ENG-CDR22008-R6-CDs Redlines.pdf Markup Summary

Subject: Text Box
Page Index: 1
Date: 9/3/2024 11:58:11 AM
Author: Jeff Rice - EPC Engineering Review
Color: ■
Layer:
Space:
Page Label: [1] 01 TITLE SHEET

SHEET
GR7
 11

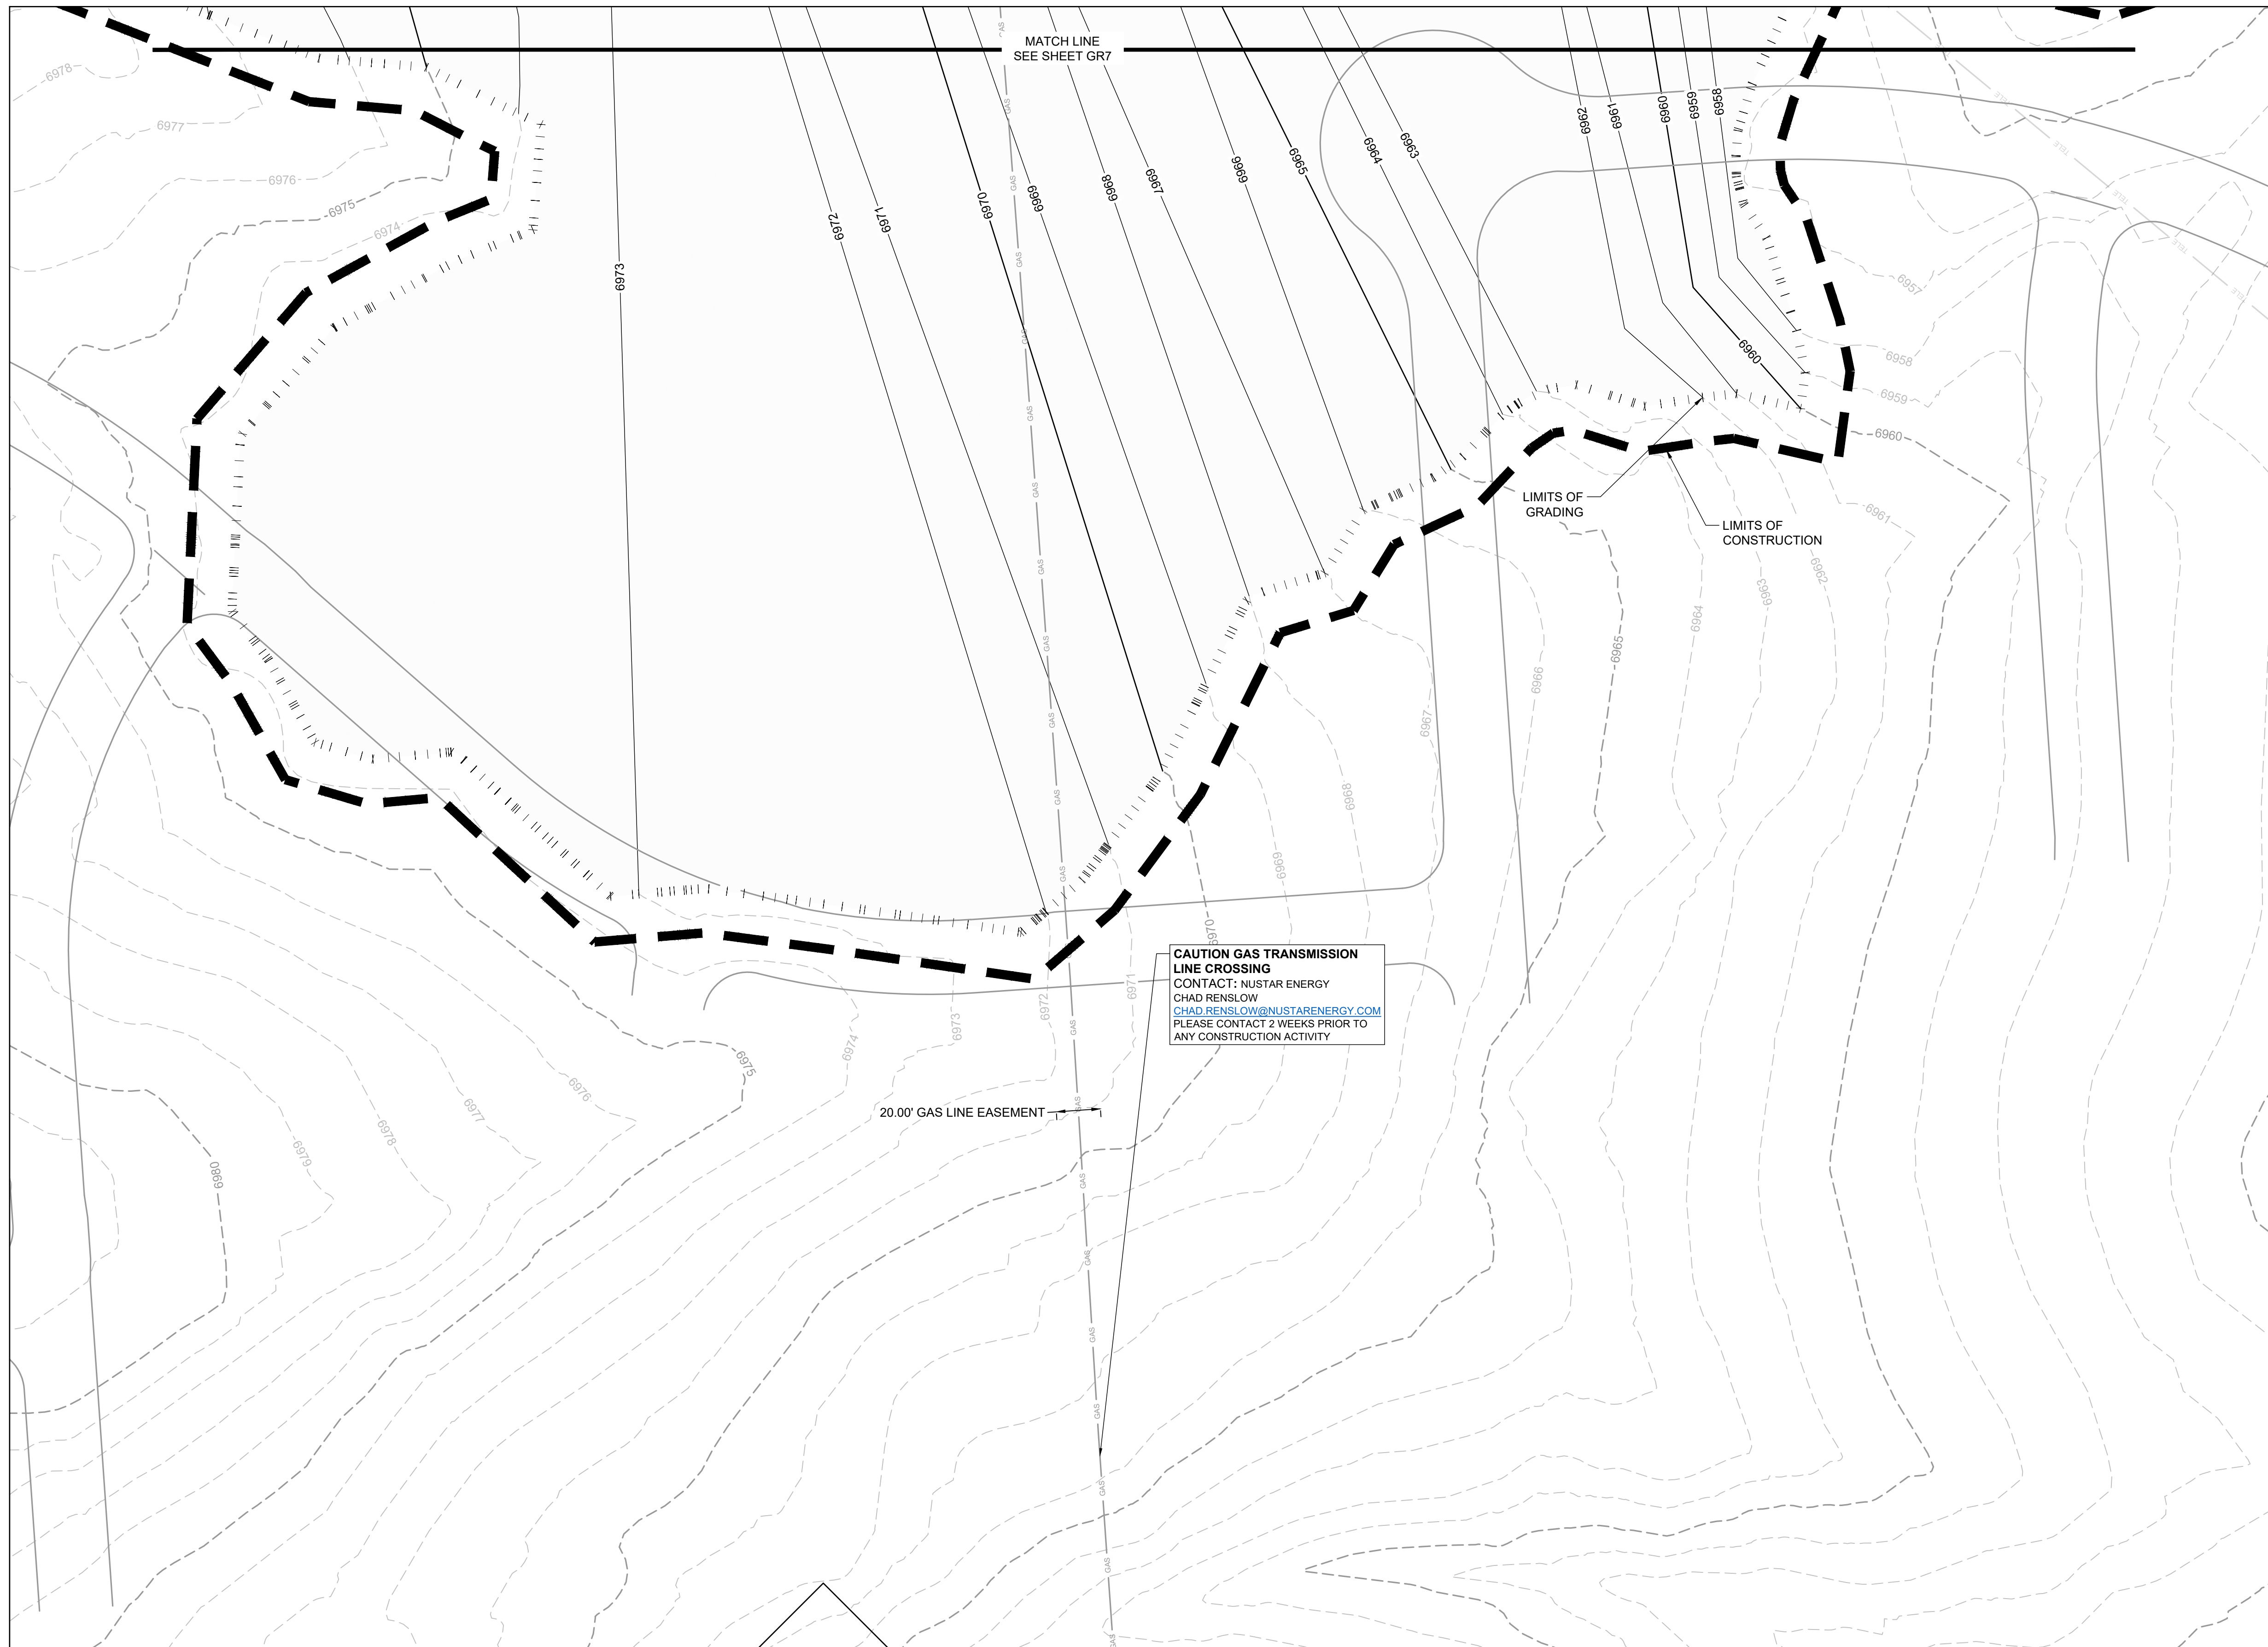
Subject: Callout
Page Index: 11
Date: 9/3/2024 12:31:49 PM
Author: Jeff Rice - EPC Engineering Review
Color: ■
Layer:
Space:
Page Label: [11] 11 TRIBUTARY 2 Valley Grading

Replace easement lines - also shts 12-24, 32-

SHEET
PP2
 31

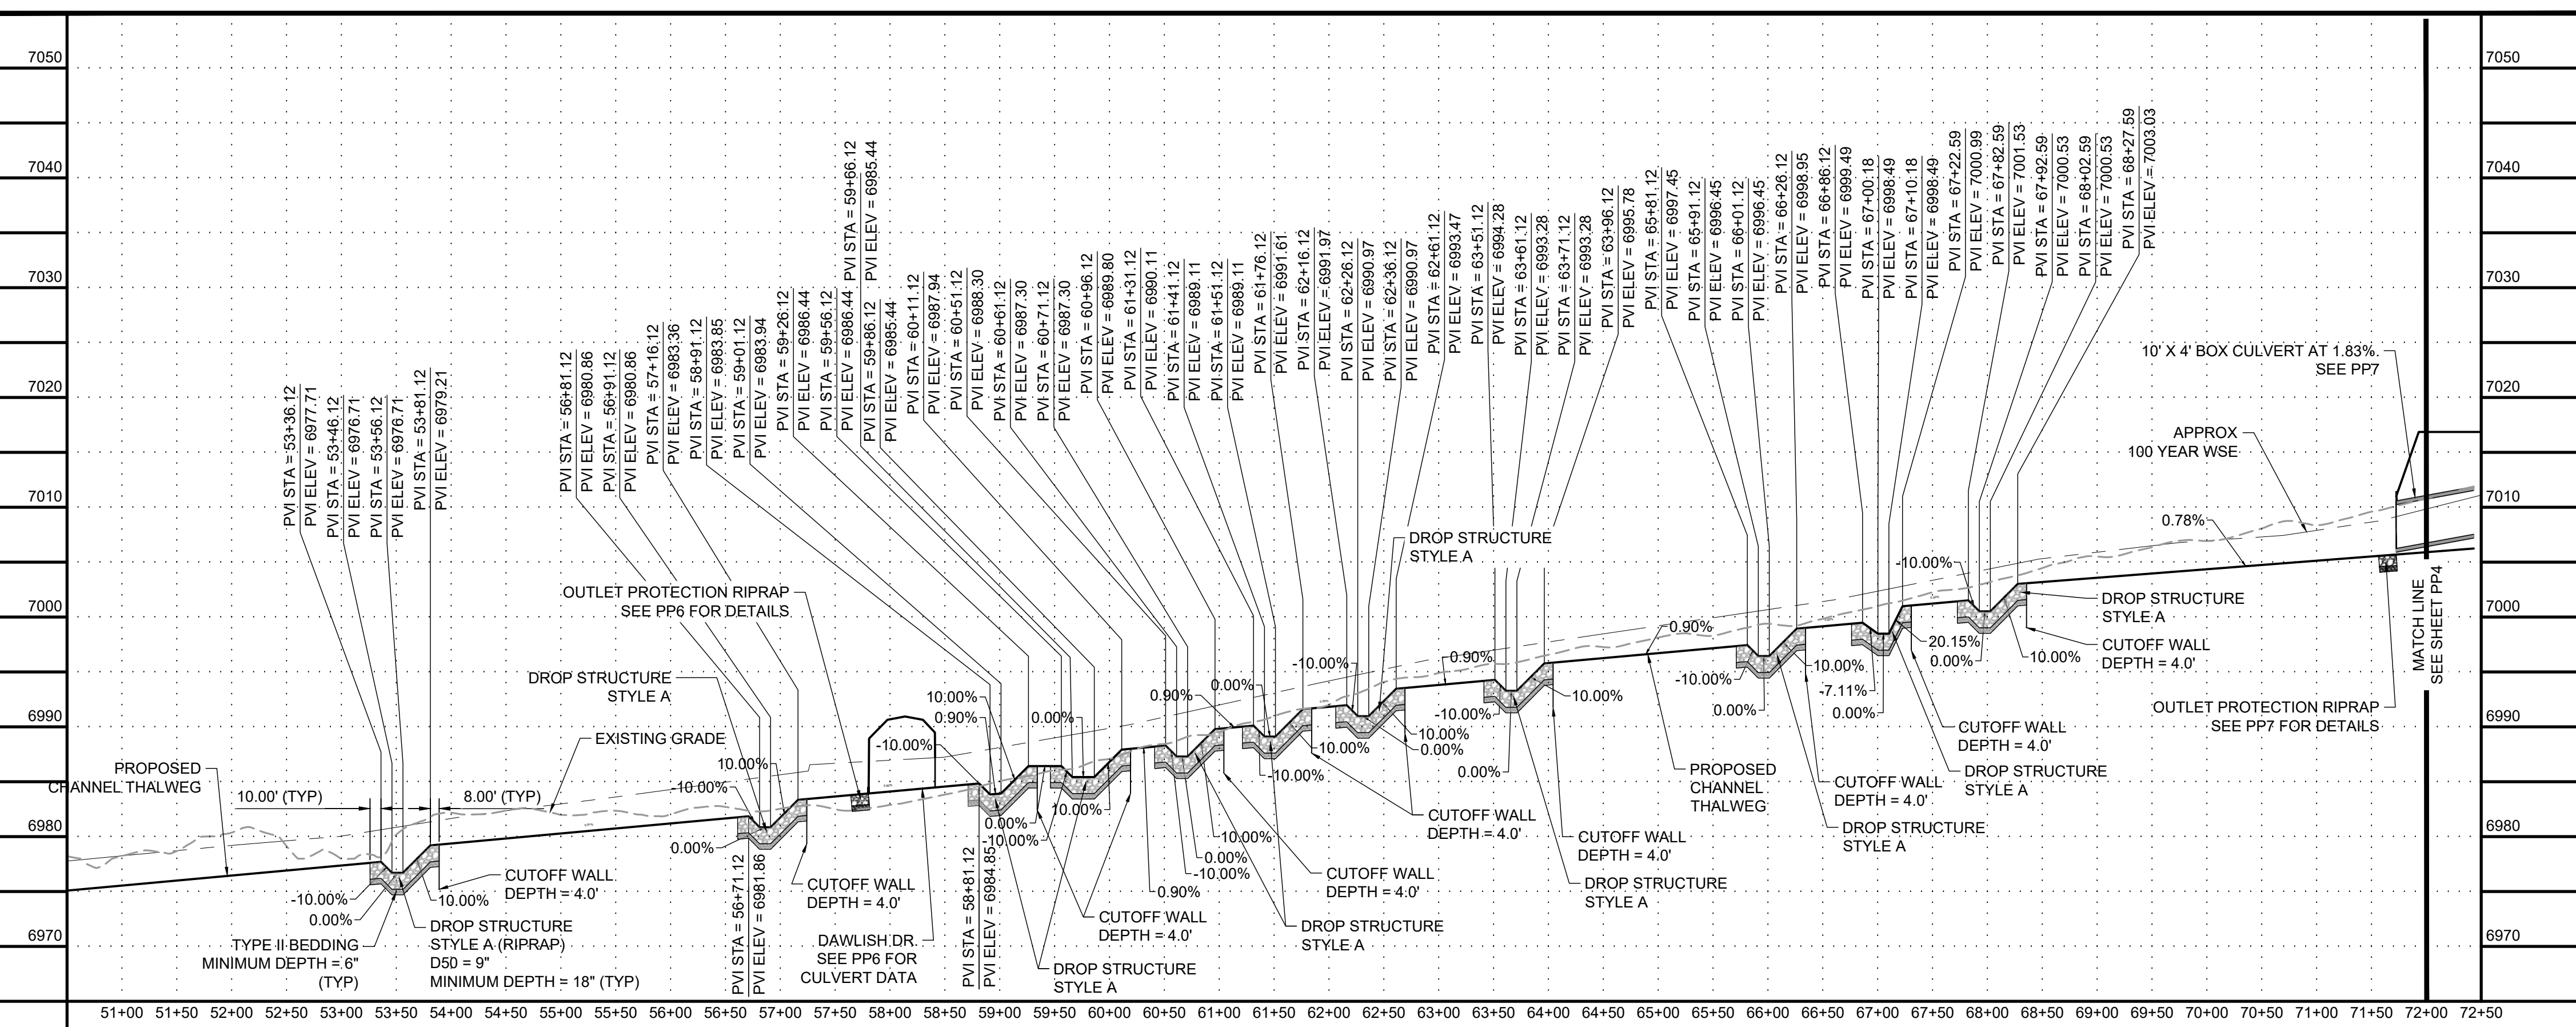
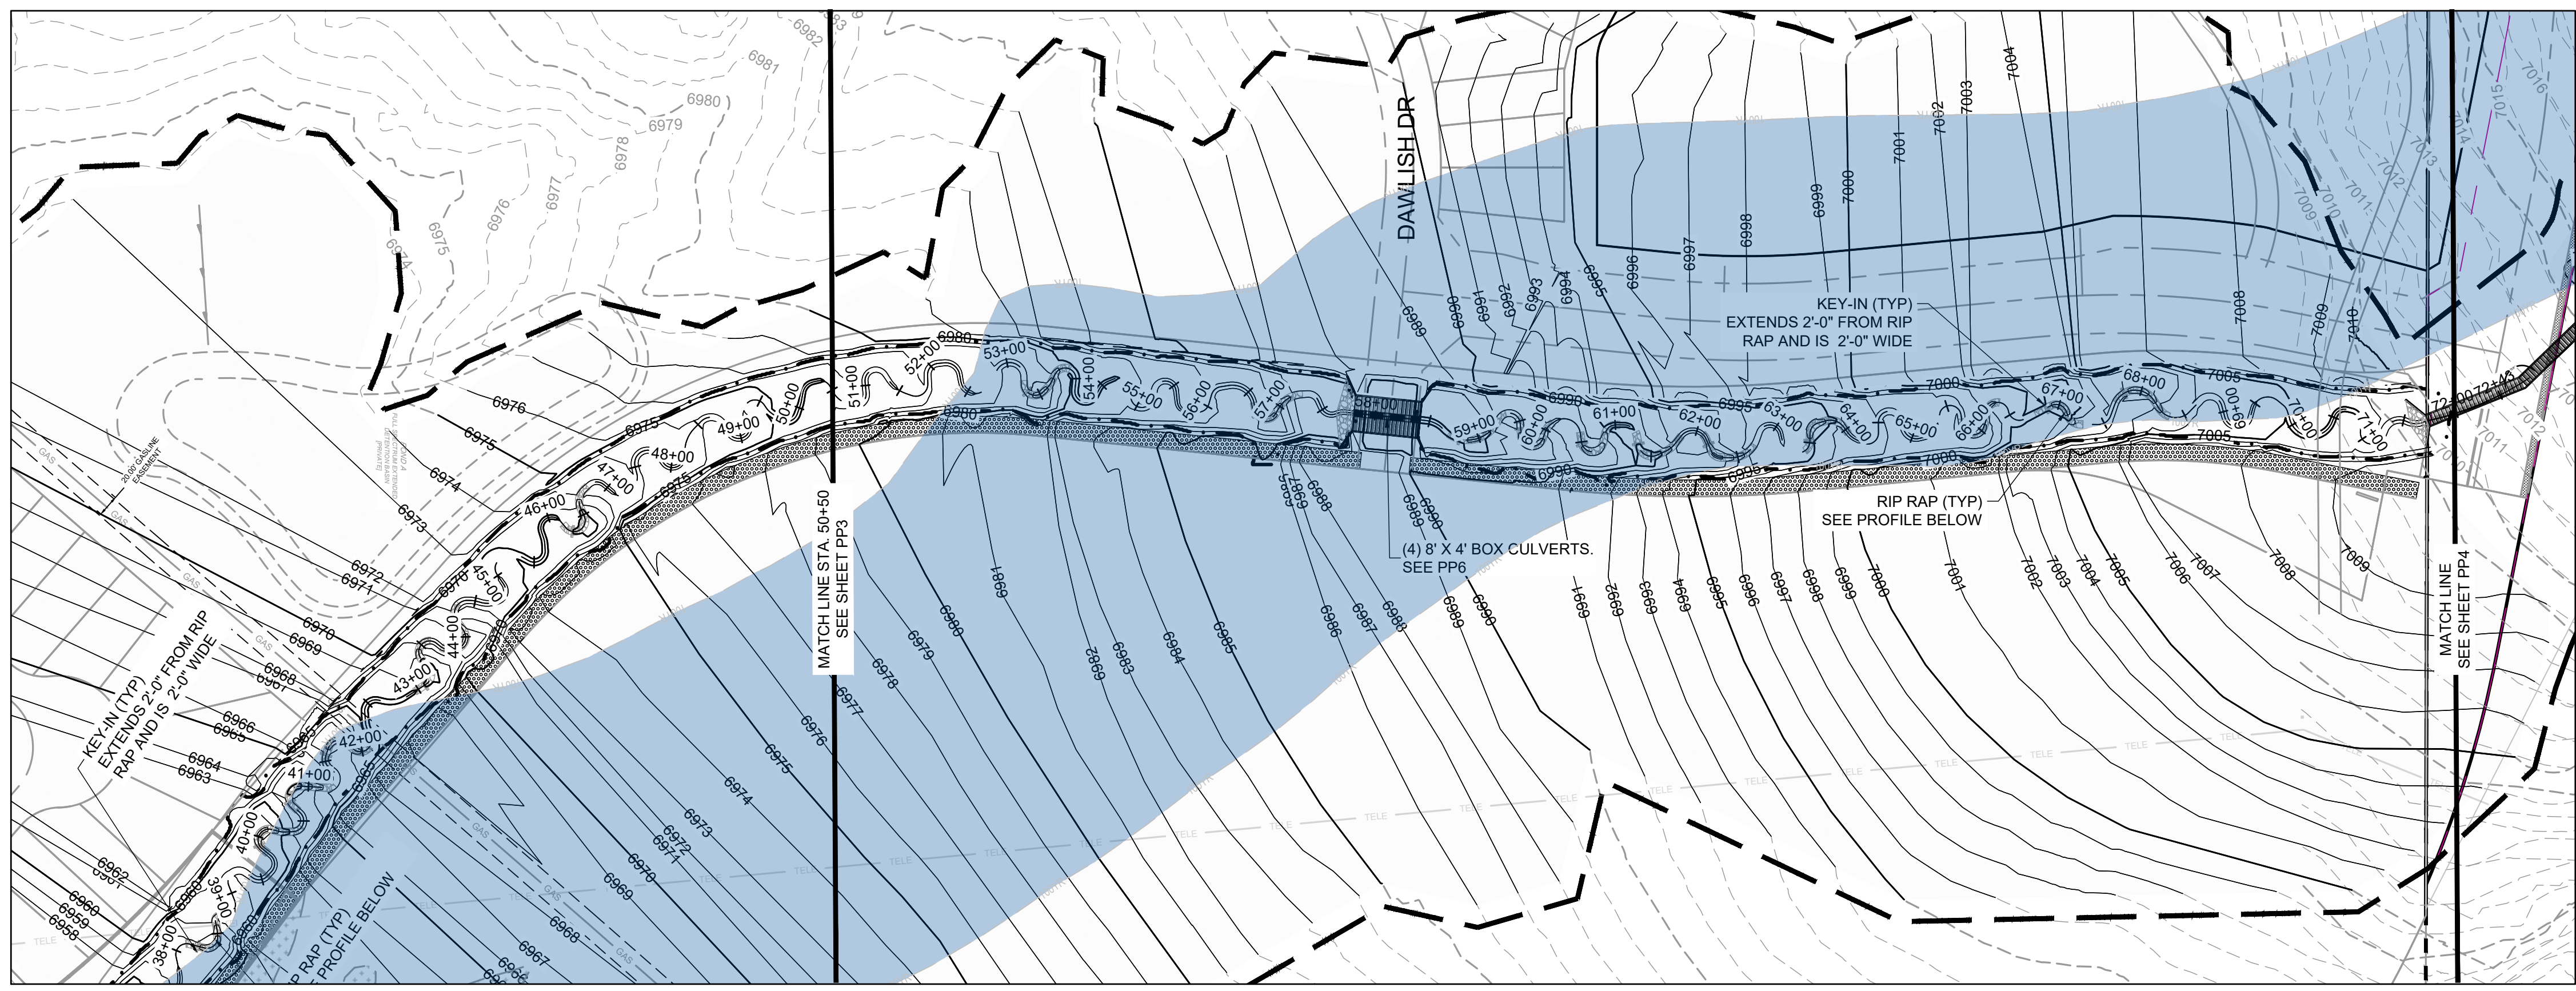
Subject: Callout
Page Index: 34
Date: 9/3/2024 12:35:43 PM
Author: Jeff Rice - EPC Engineering Review
Color: ■
Layer:
Space:
Page Label: [34] 34 DRAINAGE TRIBUTARY 2 PLAN AND PROFILE

Address apron

modeling indicates supercritical flows

show riprap
